Date 20 May 2022
Our Ref 22/00592/ADV

Town and Country Planning Act 1990 (As Amended)
Town and Country Planning (Control of Advertisements) Regulations 2007 (as amended)
4 The Derby Square, High Street, Epsom
Advertisement consent application for 1 internally illuminated fascia sign and 1 non-illuminated projecting sign for a period of 5 years.

Drawing No. DW - 005 Rev. 02

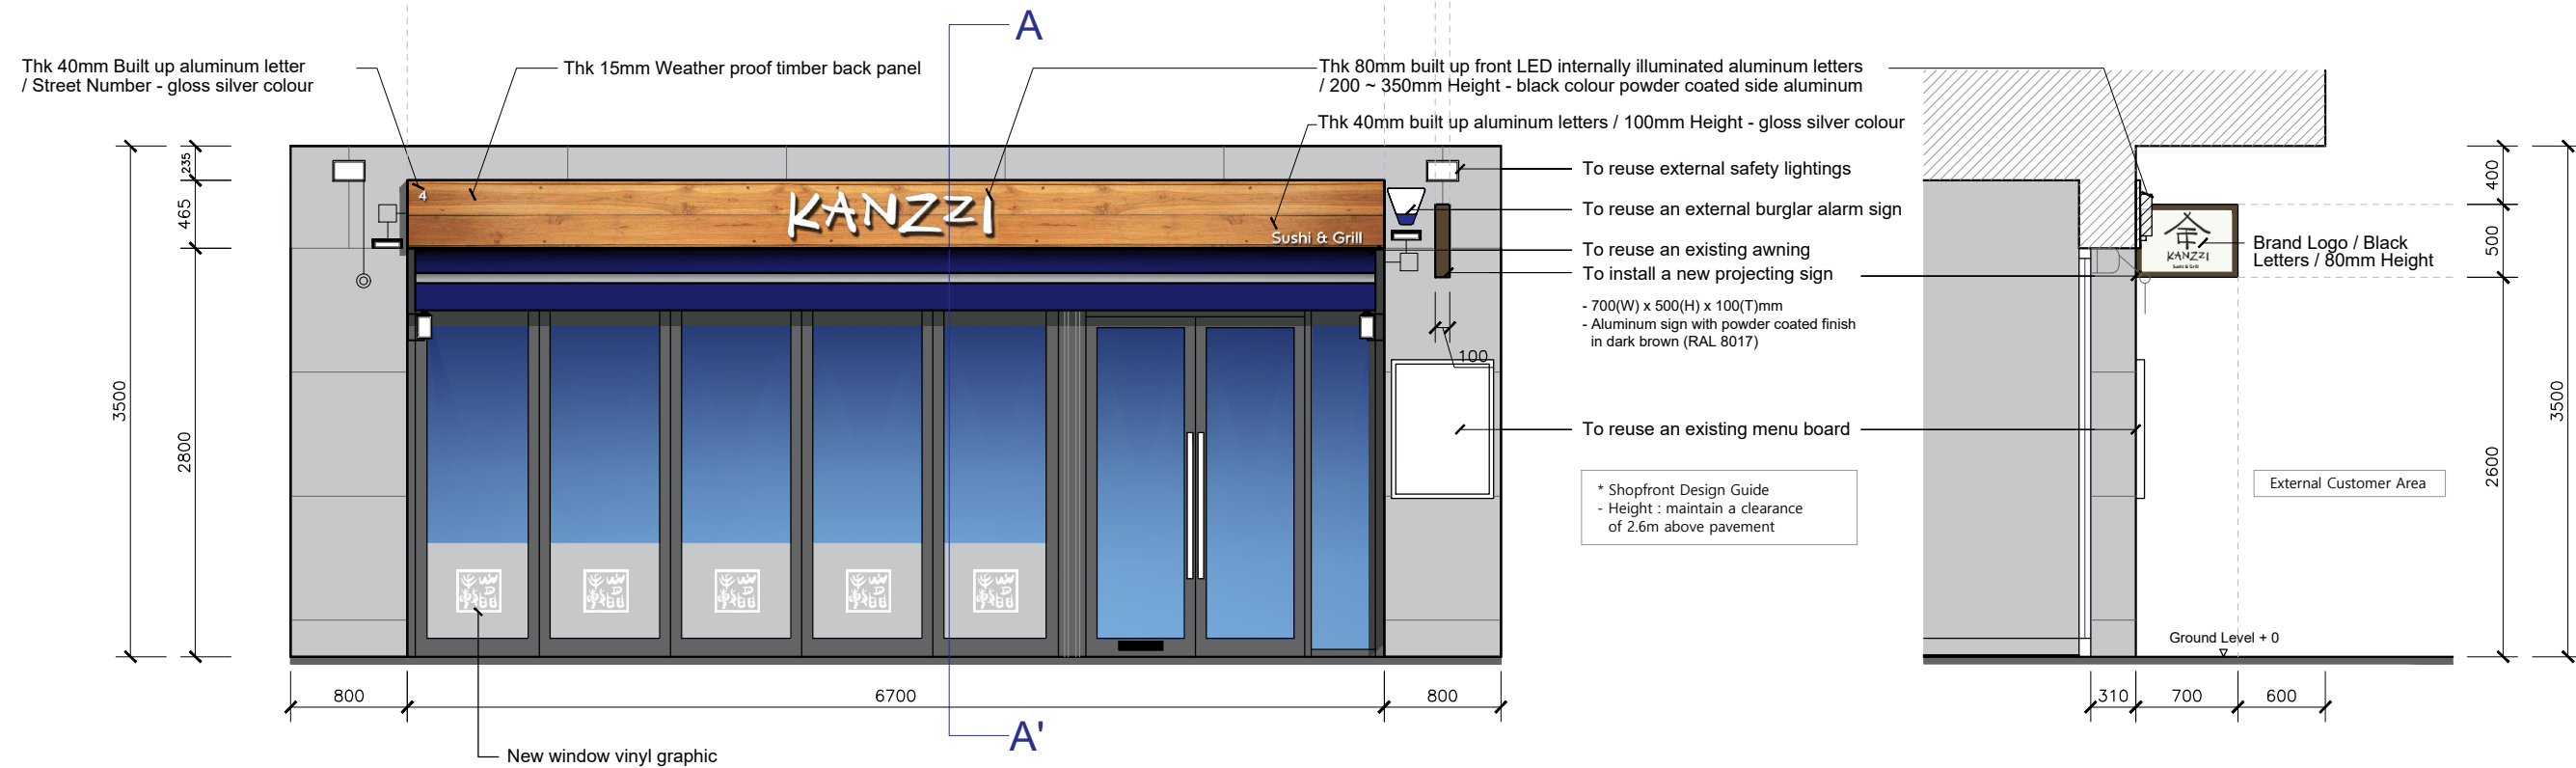
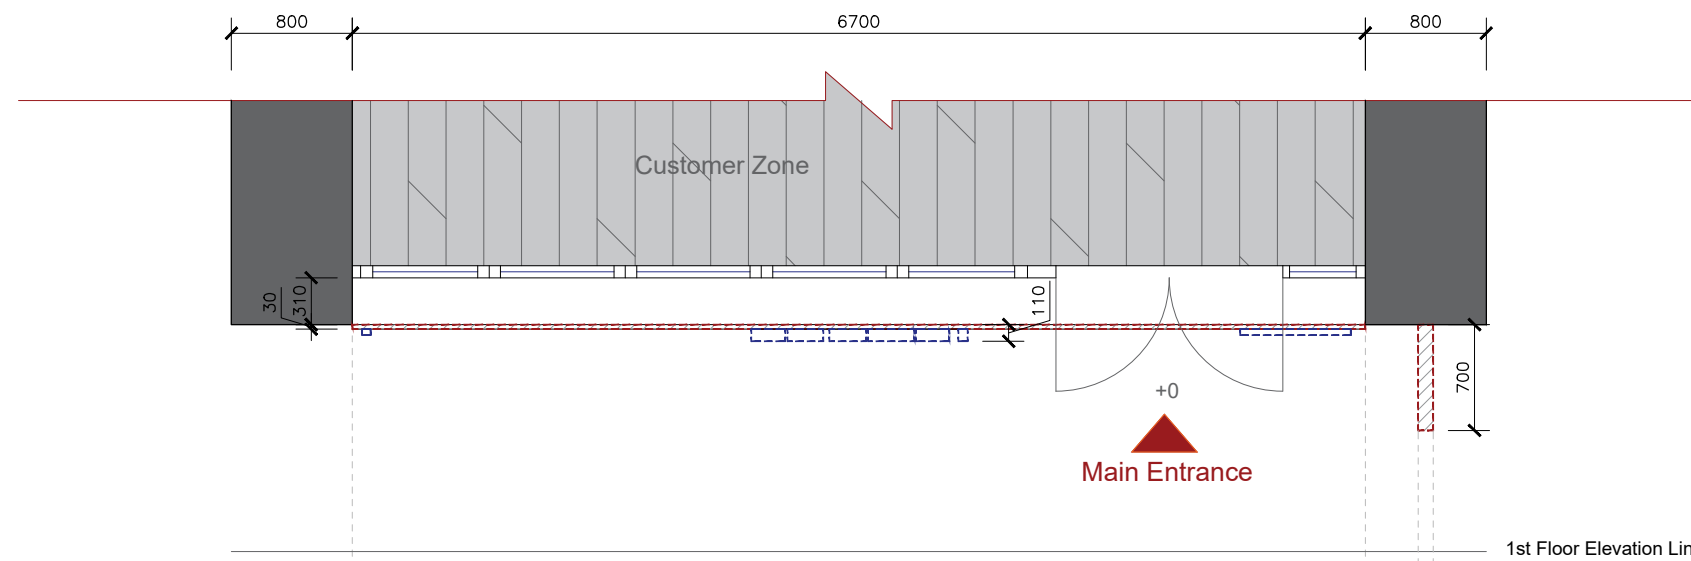
1 The application site must be outlined in red on the Site Location Plan (1:1250). Also, the application form indicates this application is for 1 internally illuminated fascia sign and 1 non-illuminated projecting sign; yet the plans indicated that there will also be some vinyl signs in the windows. Please clarify, amend the application form as necessary and provide details of the vinyl signs if applicable. If not, please remove the references for the vinyl signs from the plans.
